I'm writing to you with respect to the development at Church Lane Linthwaite, and the associated drainage Conditions, as per the attached document.

I understand that Condition 17 & 18 remain undischarged, due to ongoing queries from the LLFA. I've copied in Paul Farndale, should he wish to contact me directly for discussion, but can you please upload and issue the linked information to your appropriate central database.

**“Condition 17 – Attenuation Basin**

### **Condition 18 – Flood Routing**

TITLE: **S104 SUDS DETAILS SHEET 2 OF 2**

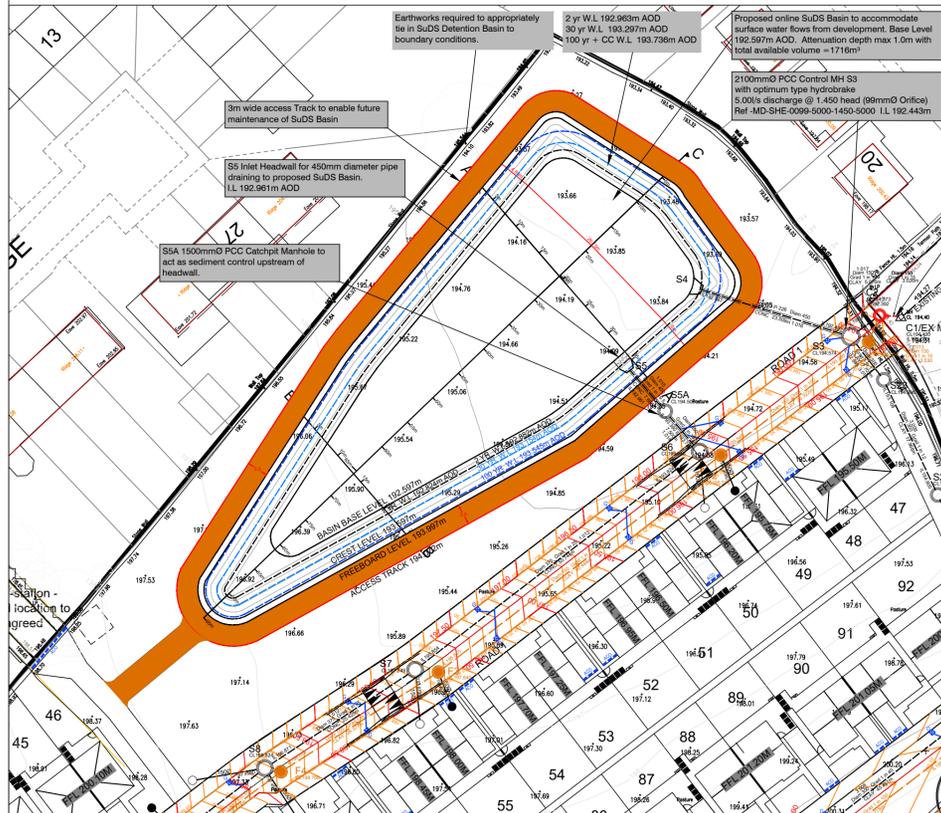
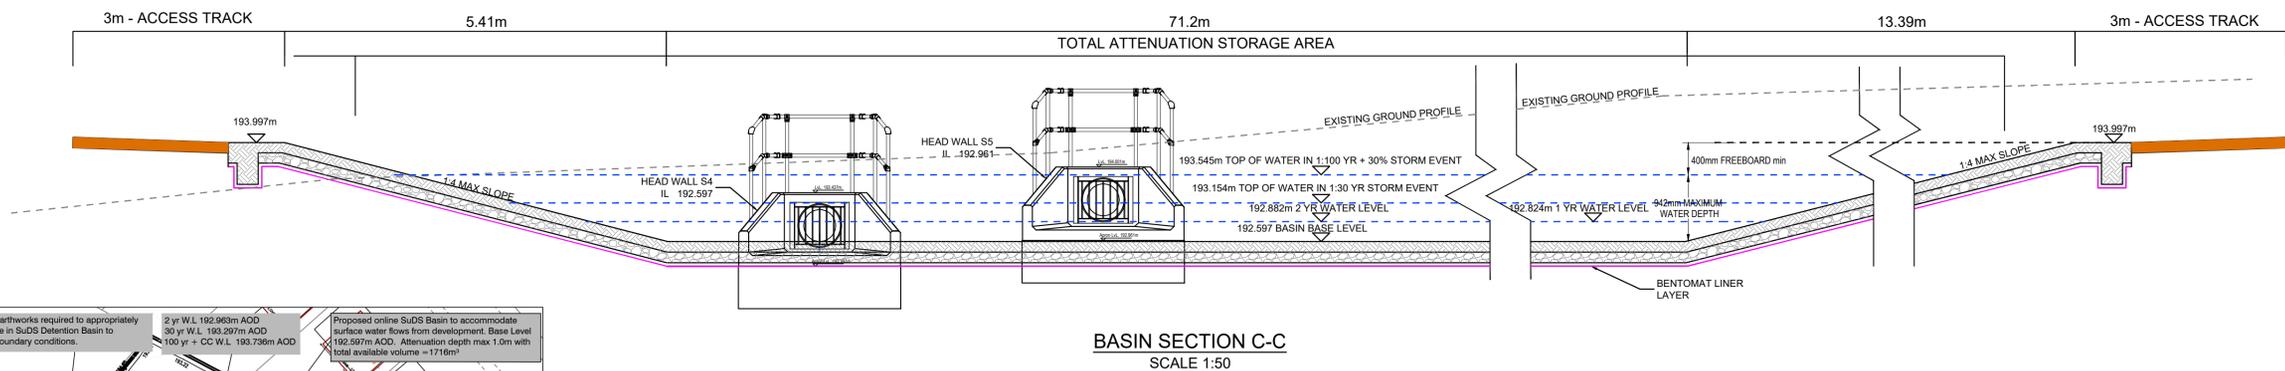
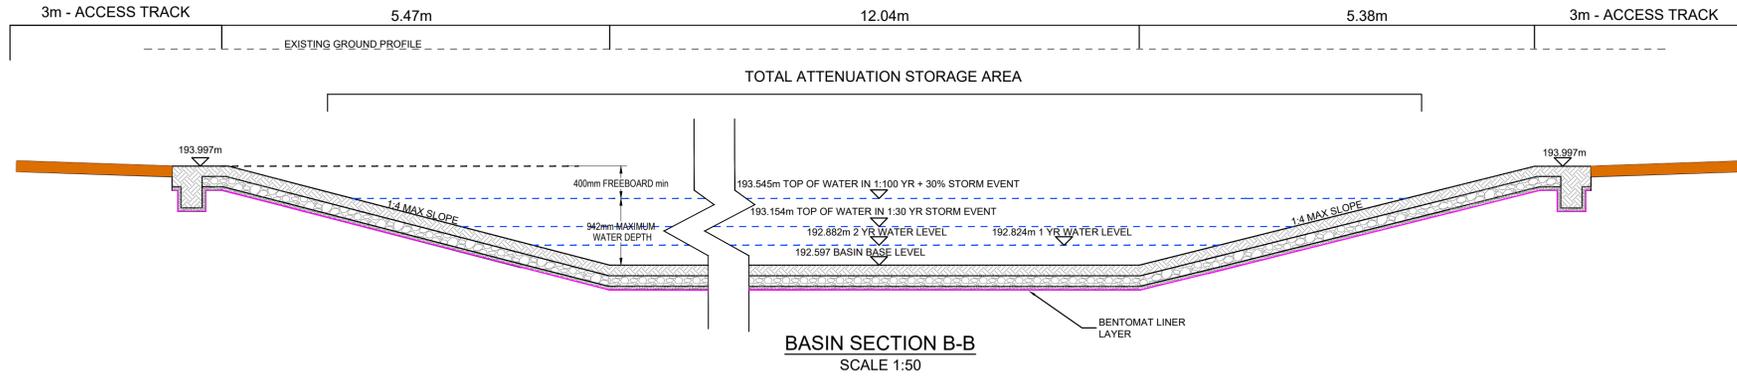
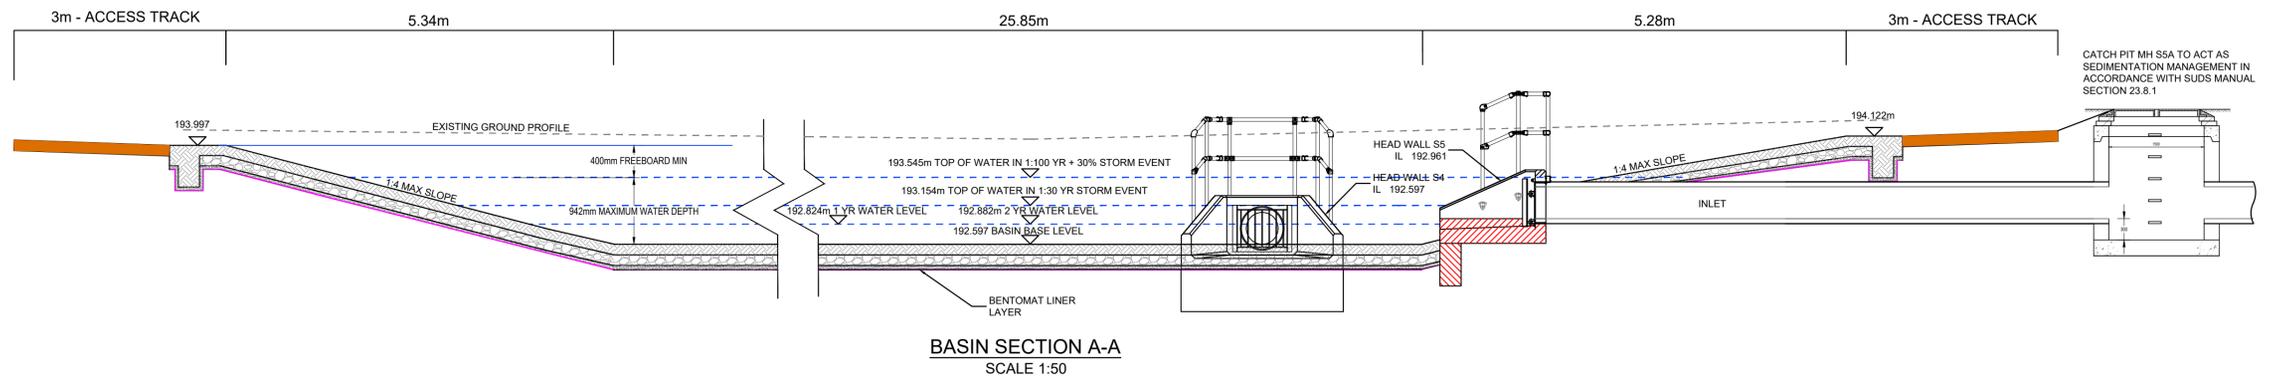
*Safety cages preventing access to incoming and outgoing pipes should be re-assessed for blockage prevention. Flush grilles are prone to blockage and a horizontal section is advised to aid overspill. We also advise raising 150mm above the invert of the pipe to lower risk of blockage from small items. This is still to be provided.*

*The area of overspill should be clearly shown on a plan. From this a narrative regarding spillways, erosion control and protection of any embankment, where applicable is still required.*

**The system is approved and being adopted by Yorkshire Water including the basin, they have legal responsibility for maintaining and operating the basin, including the headwalls. The detailed safety Cages have been approved by YW under the S104 process.**

**The Outfall Headwall has a concrete apron to offer erosion protection, as shown on the plan and sections. This level of erosion protection has been accepted by Yorkshire Water as part of the S104 Technical Approval.**

TITLE: OUTLINE DRAINAGE LAYOUT

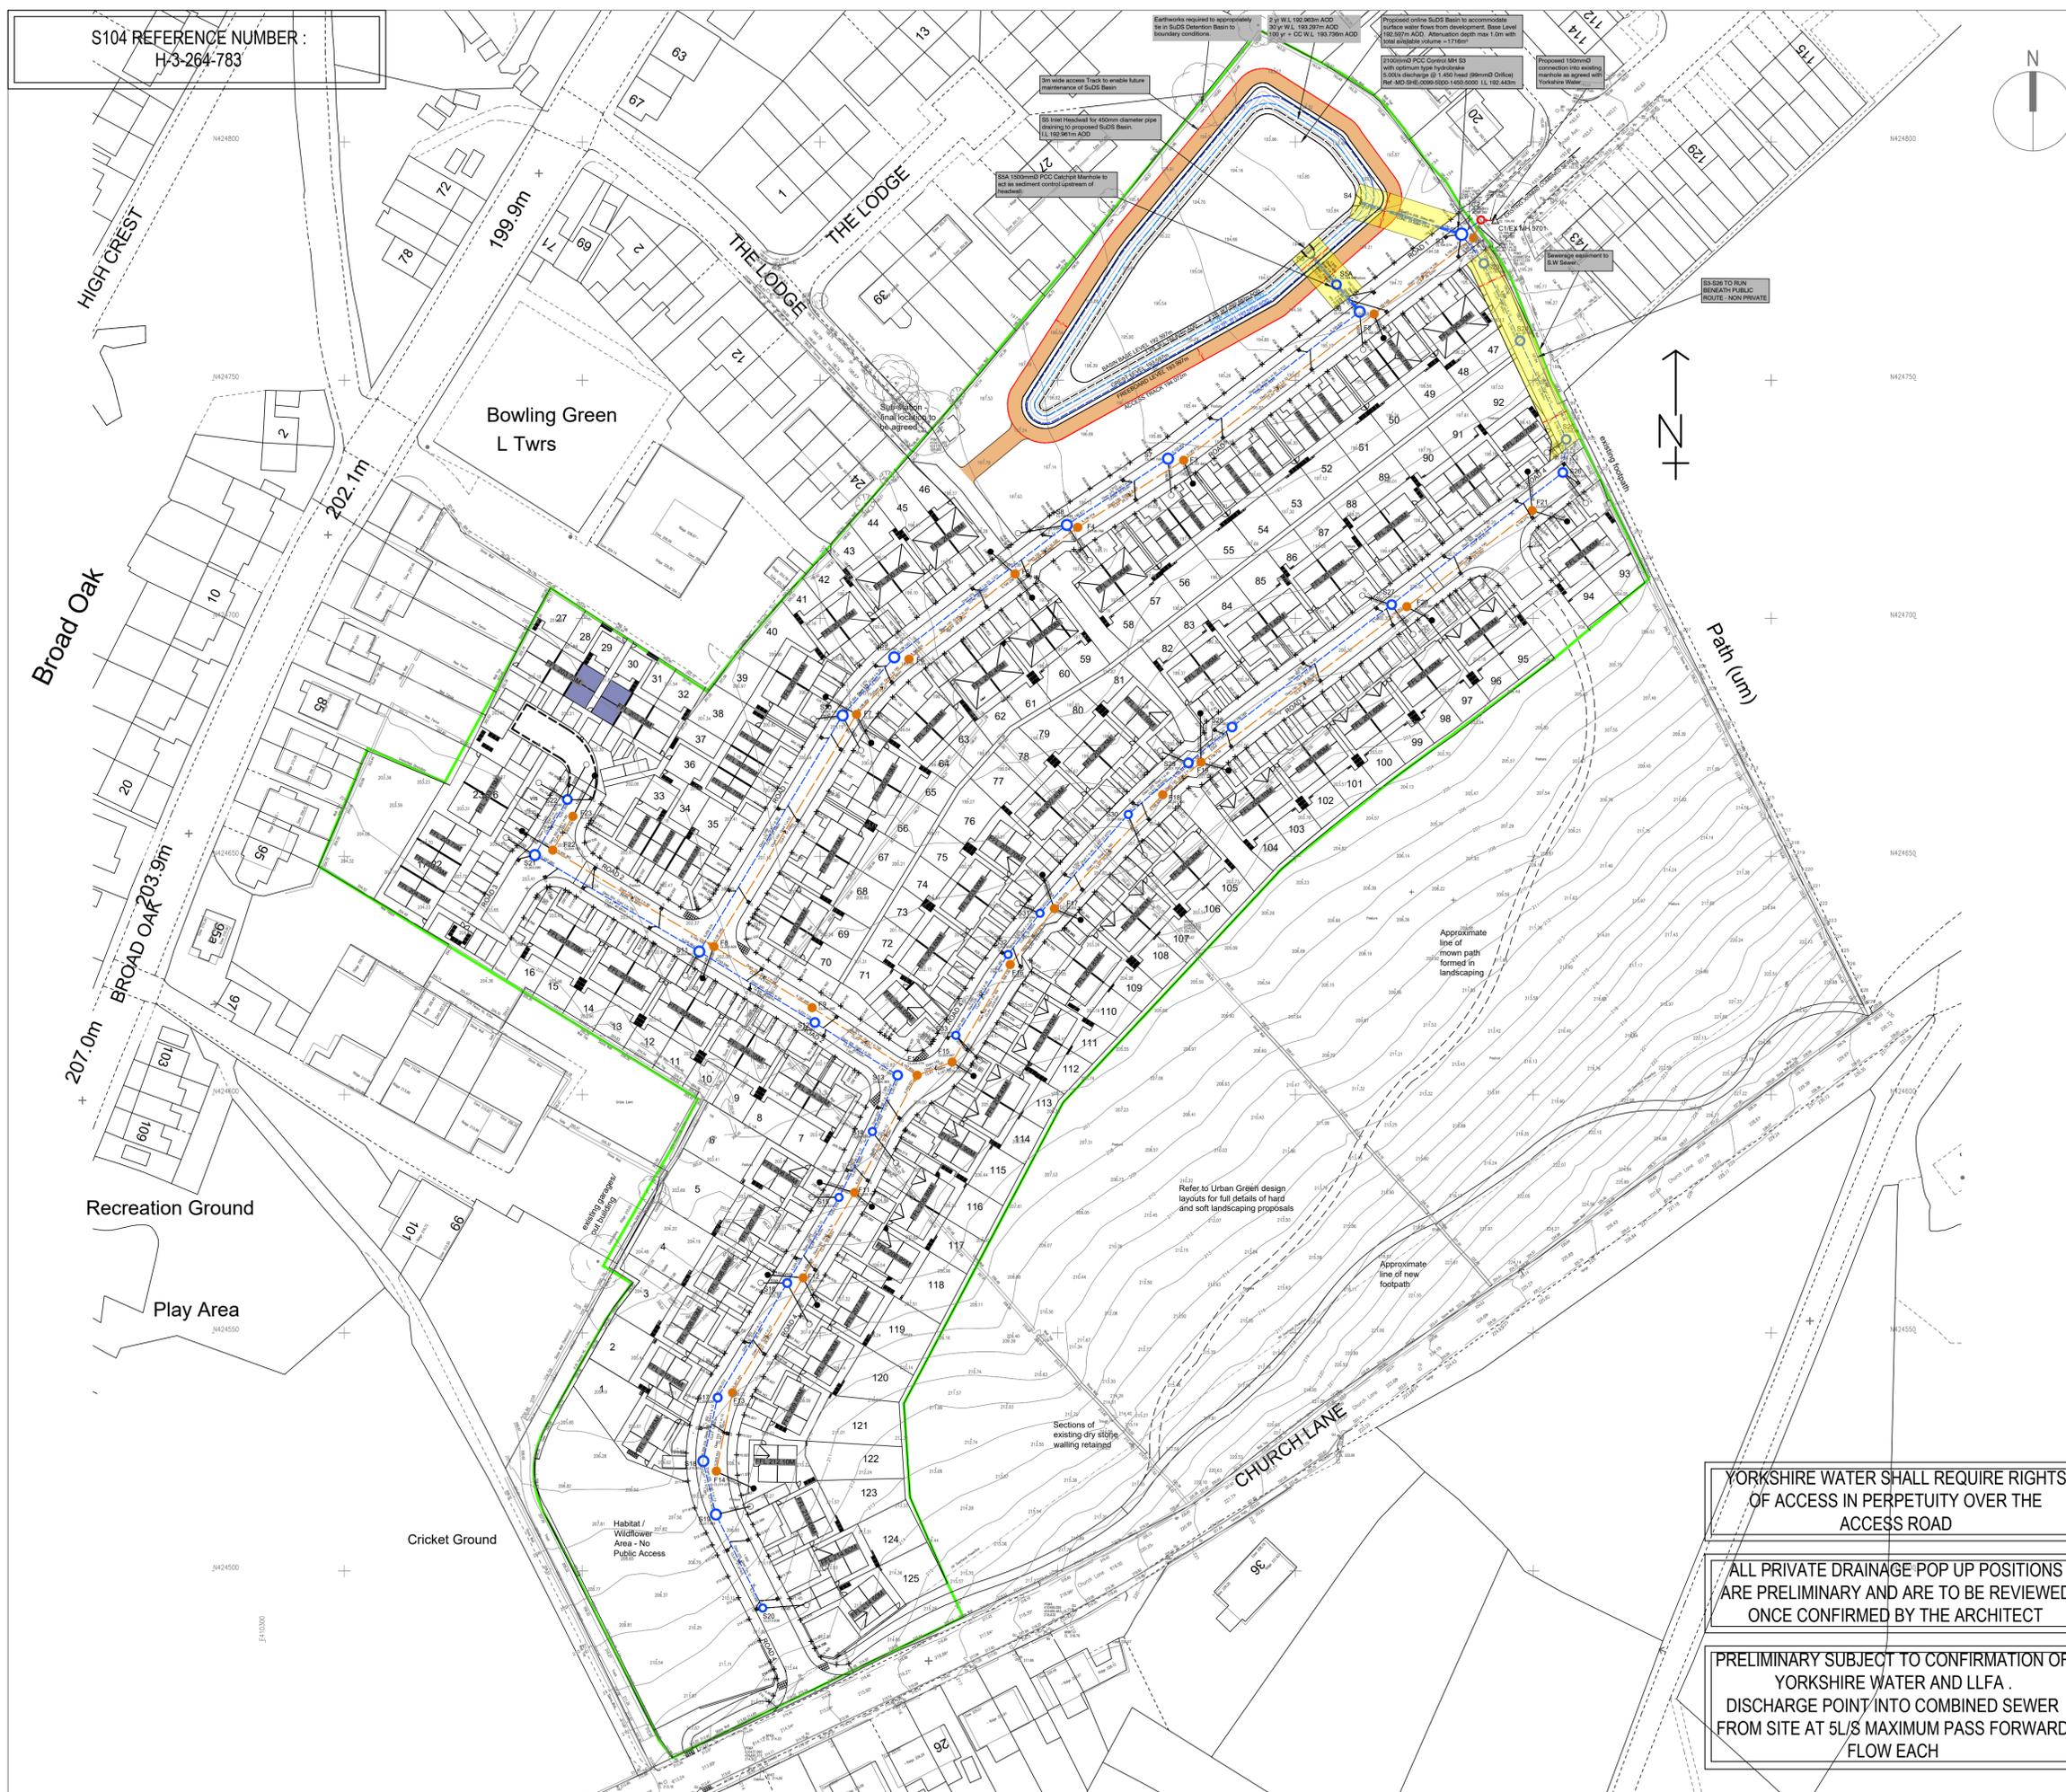
*A safety bench, located at the point of normal water level, (recommended at 3.5m wide), was provided but has been removed from the latest drawings.*

*A check on latest microdrainage calculations should show a match with the water levels on the proposed plans for the basin. Please investigate.*

**Removed, as that's an aspect of Ponds for Aquatic benching, to provide planting areas for aeration of the Pond permanent pool volume. It was not a safety feature**

**Latest Microdrainage calculations and Drawings provided, to shown that they align.**

TITLE: EXTERNAL WORKS PLAN (4 OF 4)

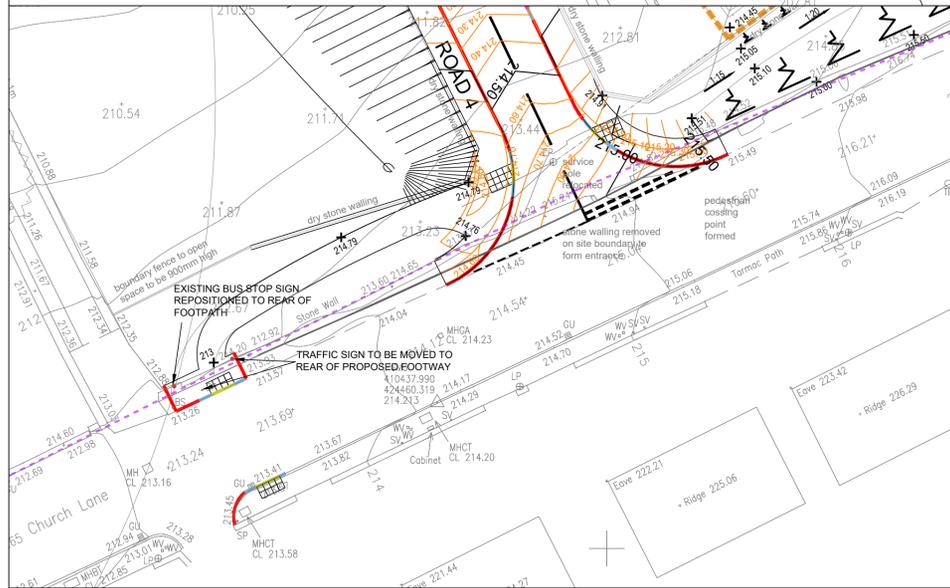
*Road contours have now been supplied but continue to show overland flow routes to a basin area in road 3. This is only acceptable if road three is isolated (use 10 properties as a marker). In initial discussions it was made clear on indicative plans that roads 2 and 1 should be used to contain overland flow into Kinder Avenue (where this has been experienced in the past), avoiding basins and new property curtilage. This has not happened. A swale has been shown prior to the southern plots backing onto sloping ground to protect these properties from surface run off. However, no levels have been shown for the swale, just a contour profile for the land suggesting low spots at the backs of properties and that they will be at risk. Flows should escape using the road network and/public open spaces, avoiding property curtilage. A detailed examination of levels is therefore required here to prove it is achievable.*

**We have received the levels of Road 3 to avoid a basin area, this was submitted and approved through the S38 process, with Road 3 sufficiently lifted to avoid creating this effect. Additional levels to the external works plan are shown for the Swales to demonstrate transfer of flows away from properties. The new level scheme also eliminates are Flooding for the 1 in 100 year storm event.**
